App no: **20.0389**

Address: **Land at Eastham House Farm Mitton**

Proposal: **Proposed agricultural building**

Description
SITE PLAN (Sheet 1)
By
JP

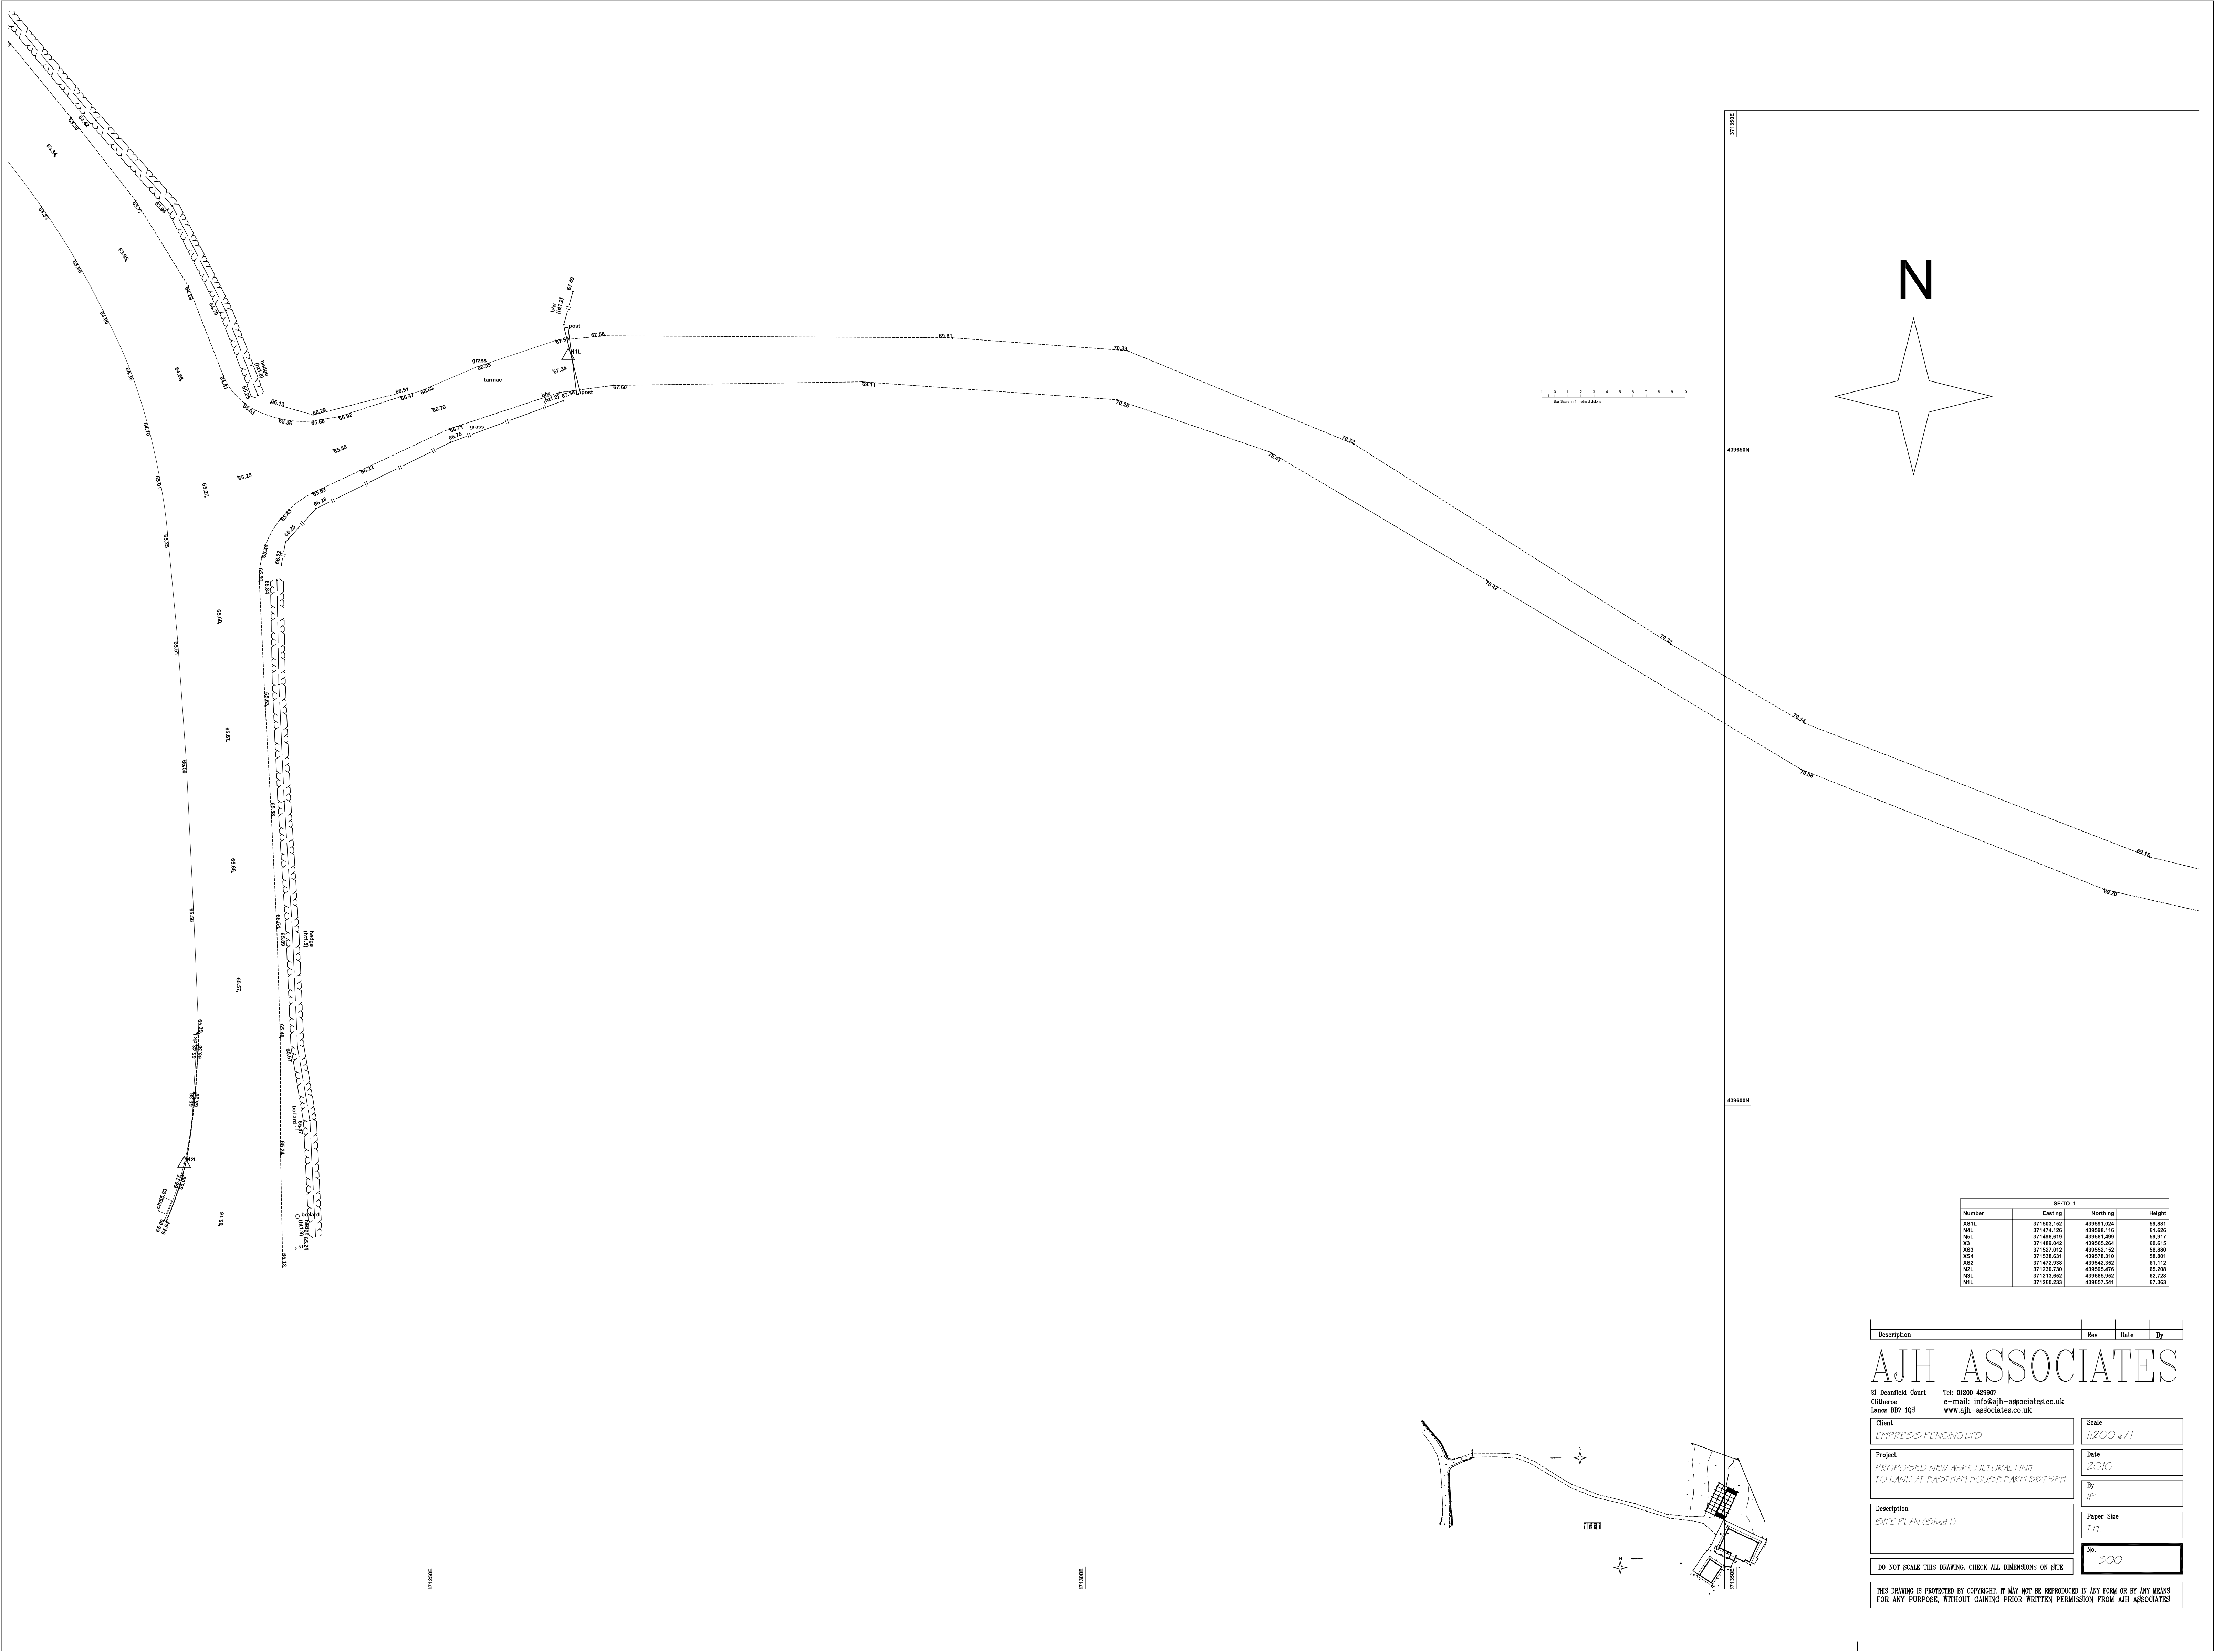
There is a concern due to the unmade surface of the site access and the gradient, which slopes toward Clitheroe Road. This could result in loose debris being deposited onto the road which would have a detrimental impact upon highway safety.

If there are additional movements associated with this proposal, other than the during the construction phase, then I would recommend that a planning condition is stated requiring the first 10m of the site access to be paved and drained prior to the first use of the building to mitigate the impact. An informative note is requested to direct the applicant to LCC developeras@lancashire.gov.uk to seek the appropriate agreement for the works tying into the highway.

The site access junction Clitheroe Road should remain ungated. I note that there are proposals to alter the gating arrangement however it is important to note that any new gates erected should be set back at least 10m or increased for the longest vehicles which may need to access the site.
